**KIRKLEES METROPOLITAN COUNCIL
INVESTMENT & REGENERATION SERVICE**

**DELEGATED DECISION TO DETERMINE APPLICATIONS FOR
NON-MATERIAL AMENDMENTS**

Reference No: **2026/NM/90780/W**

Description: Non material amendment to previous permission
2025/93073 for erection of first floor side extension,
hip to gable, dormer and associated works

Project: 7 WOBURN DRIVE WATERLOO, HUDDERSFIELD	Job No: 2025-011
Title: PROPOSED PLANS & ELEVATIONS	
Scale: 1:50@A1	Drawn by: AP
Date: MAY 25	Checked by: -
Drawing No: 2025-006(20)002	Revision No: -

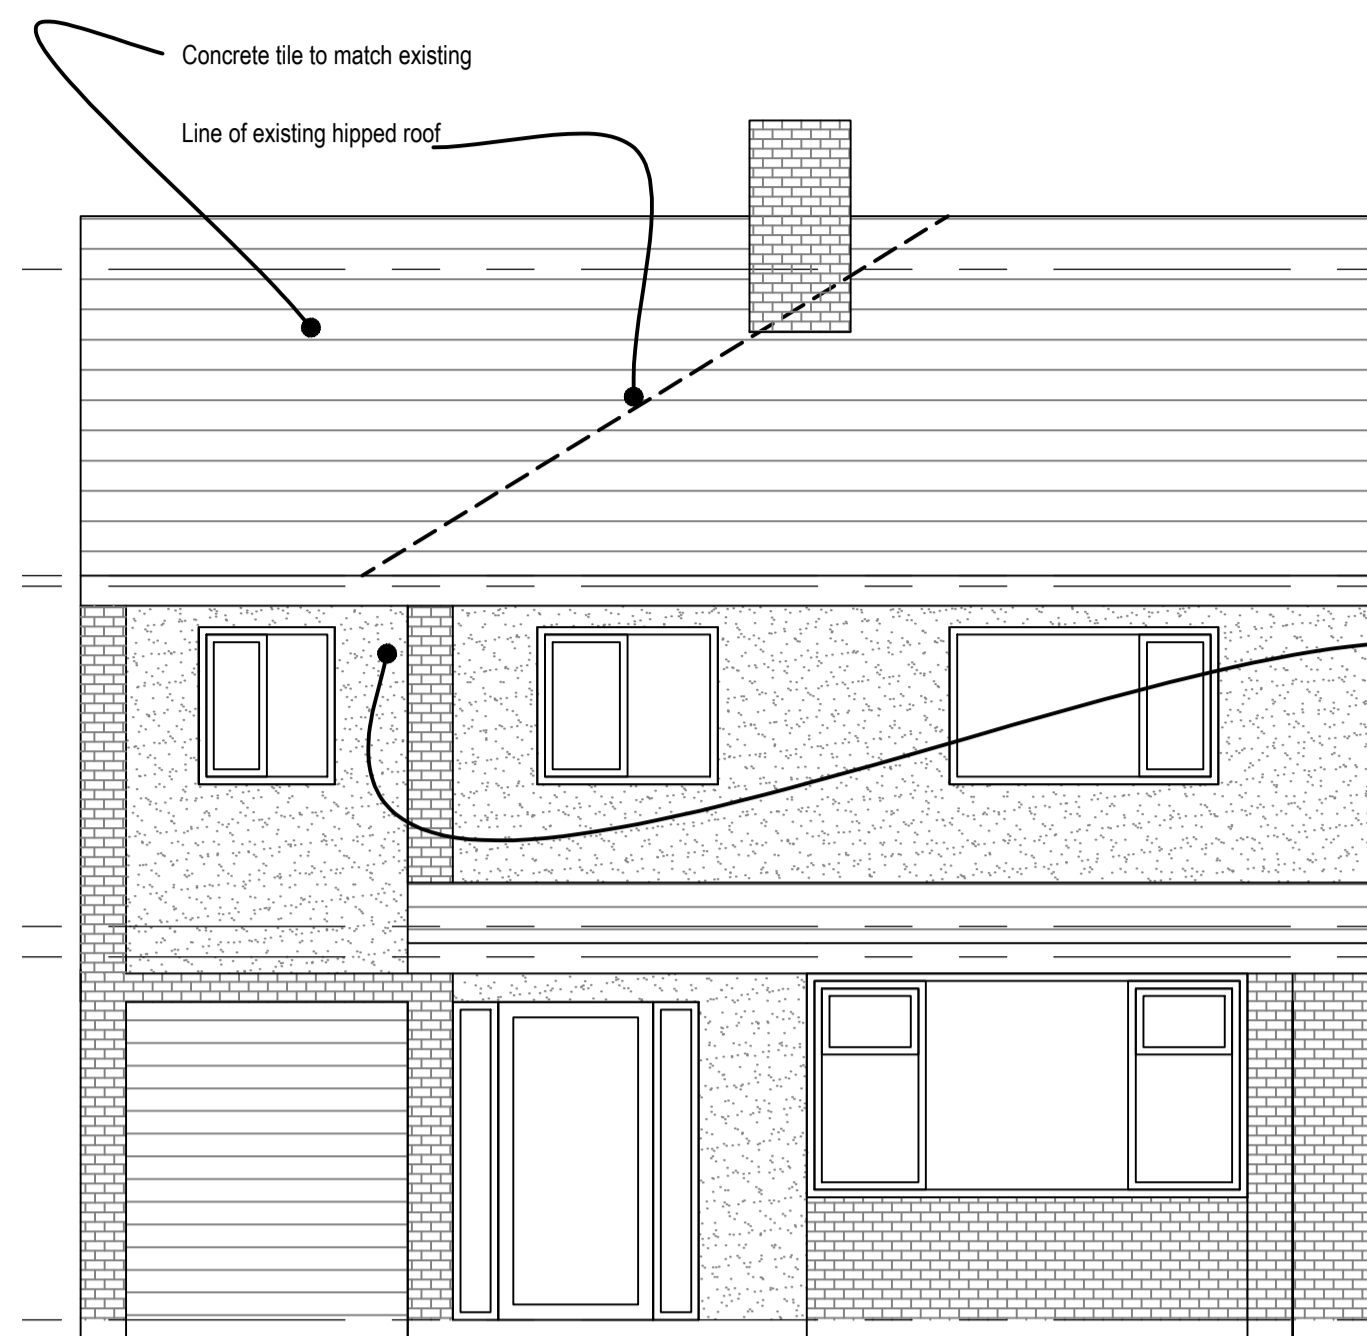
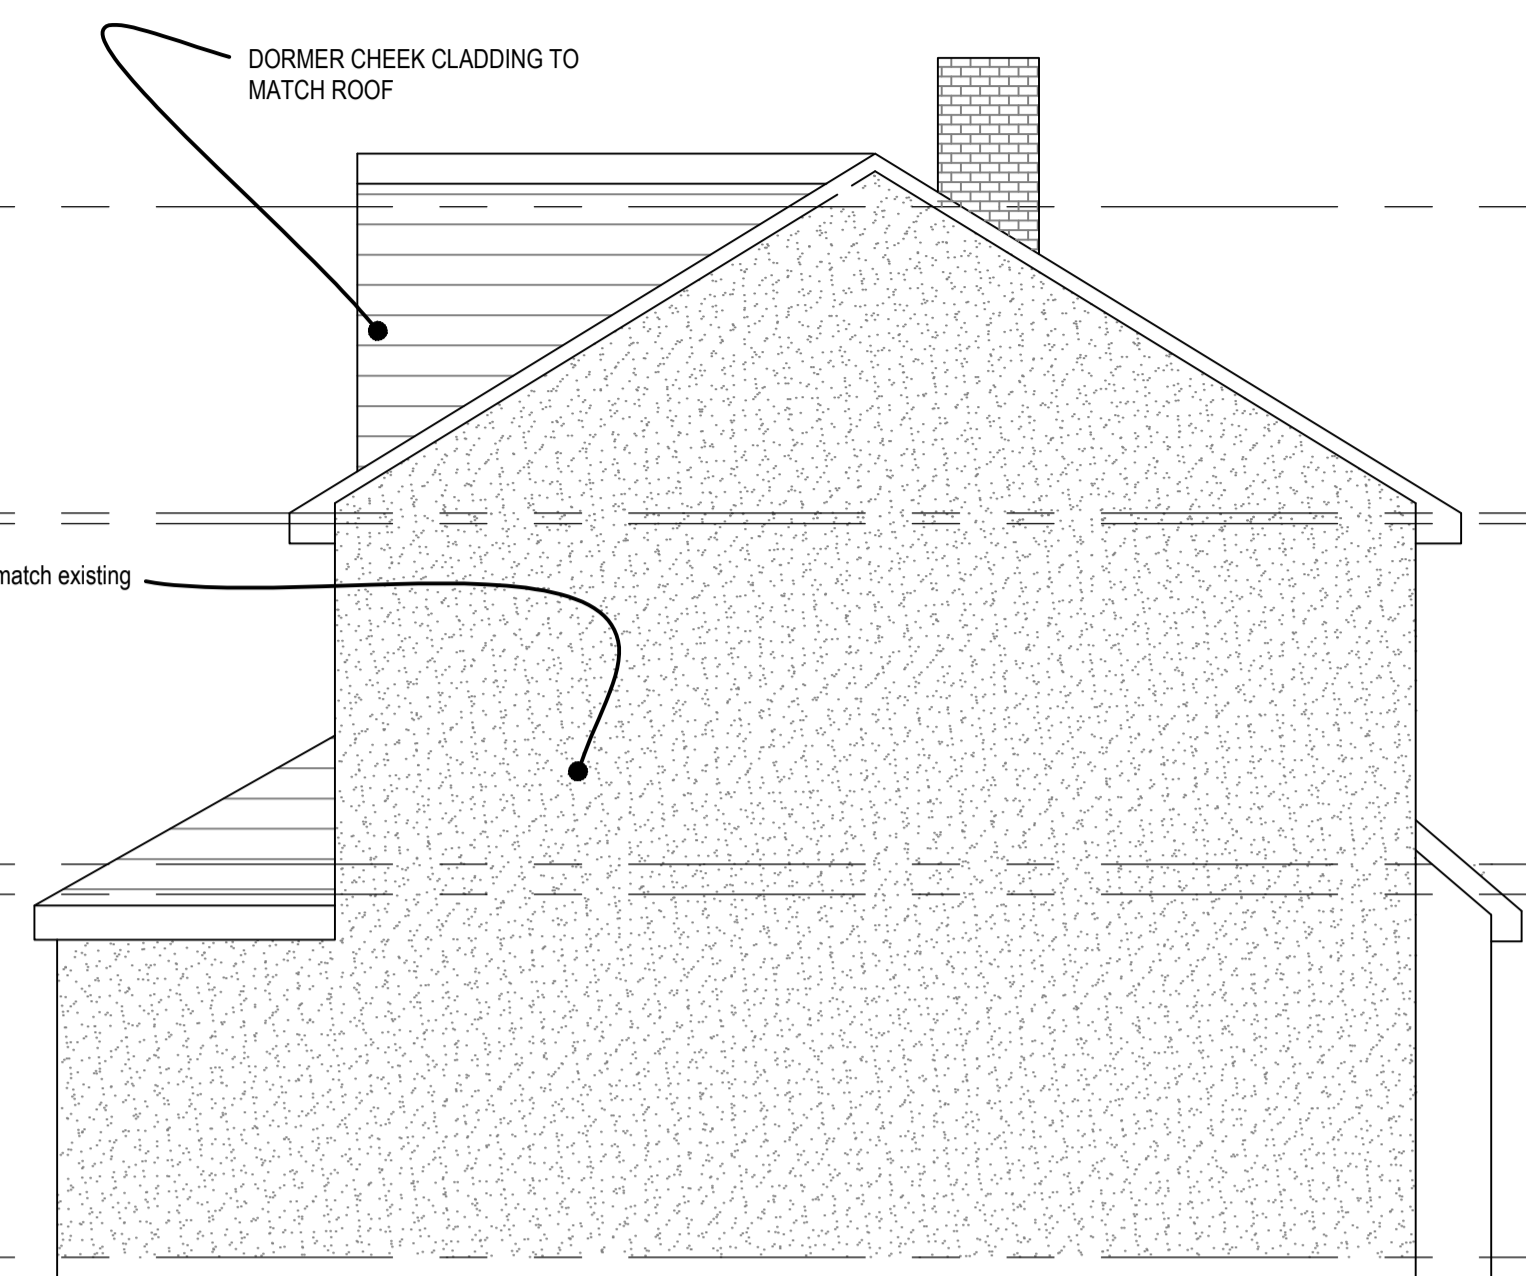
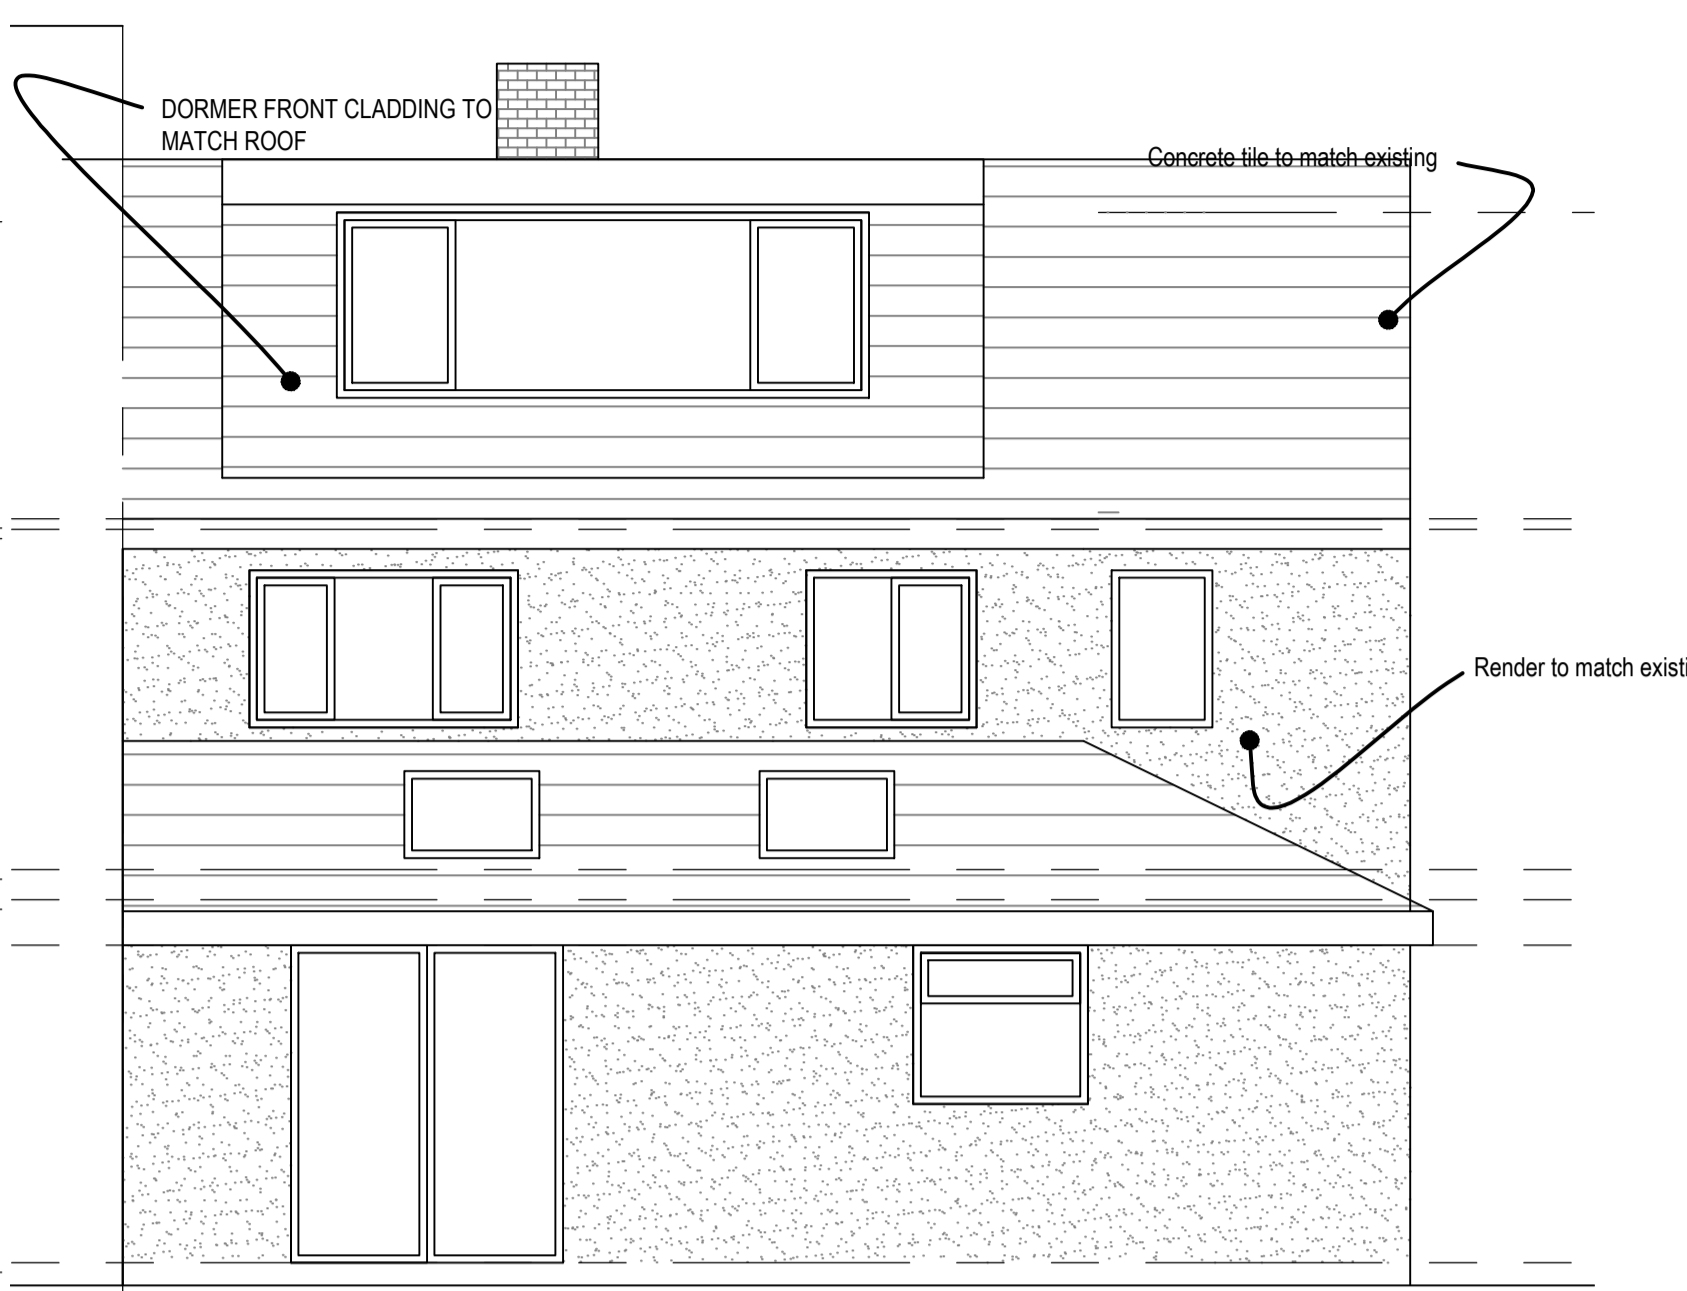
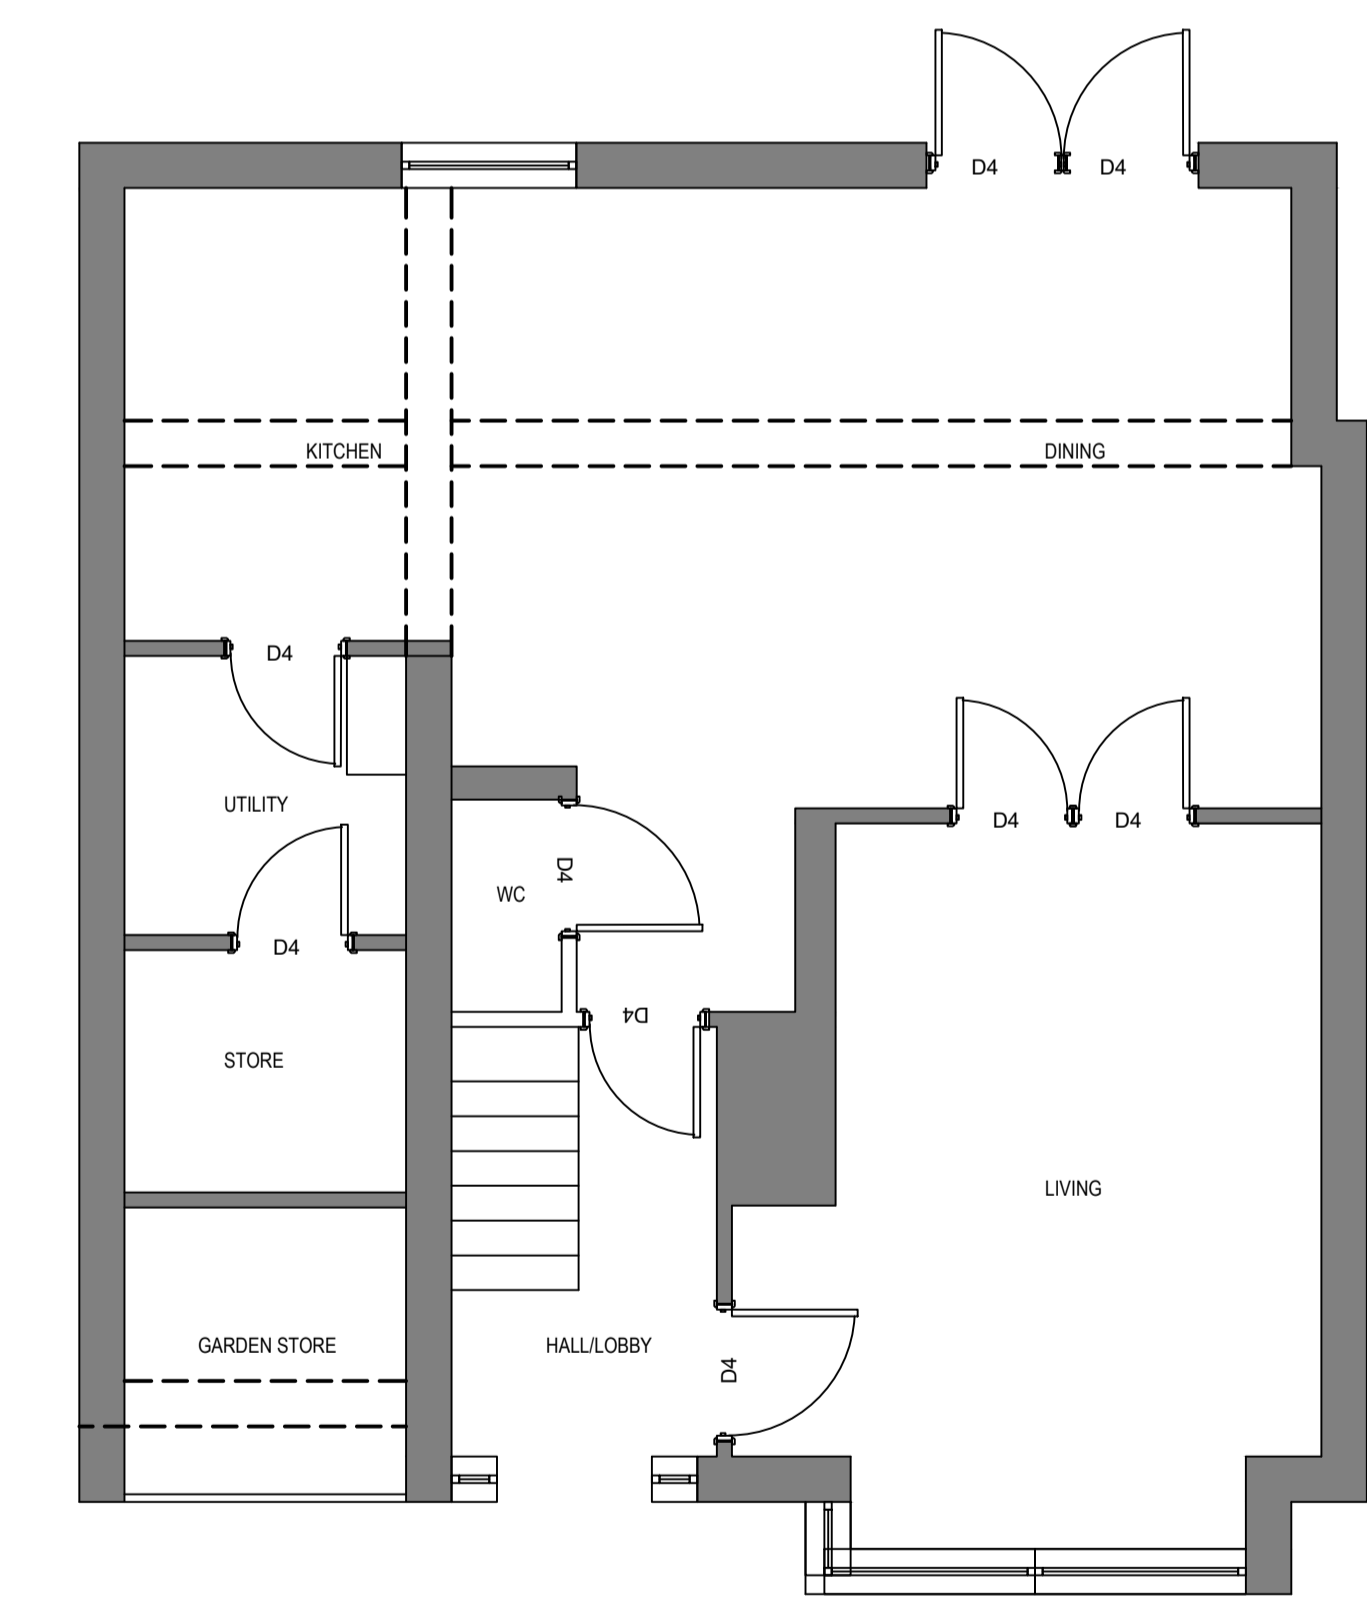
In relation to the original approval, the approved first floor side extension was approved due to its compliance with the Councils House Extensions and Alterations SPD. The proposed amendment would result in the extension being contrary to the House Extensions and Alterations SPD for first floor side extensions. Furthermore, this addition would not allow a visual break from the original dwelling thereby not appearing subservient to the host, causing the property to appear unusually enlarged and unsympathetic in the context of the street scene.

The inclusion of the hipped to gable and dormer extension cannot be considered as inconsequential to the original approval.

As aforementioned, the proposed amendments would result in extensions that would not appear subservient and therefore unsympathetic in the context of the street scene.

Due to the inclusion of the rear dormer, the interest of a third party or body who participated in or were informed of the original decision would be disadvantaged.

The amendments shown on drawing No. '2025-011-(20)002 Rev_A' are not considered appropriate to be regarded as a non-material amendment to the previous planning approval 2025/93073.
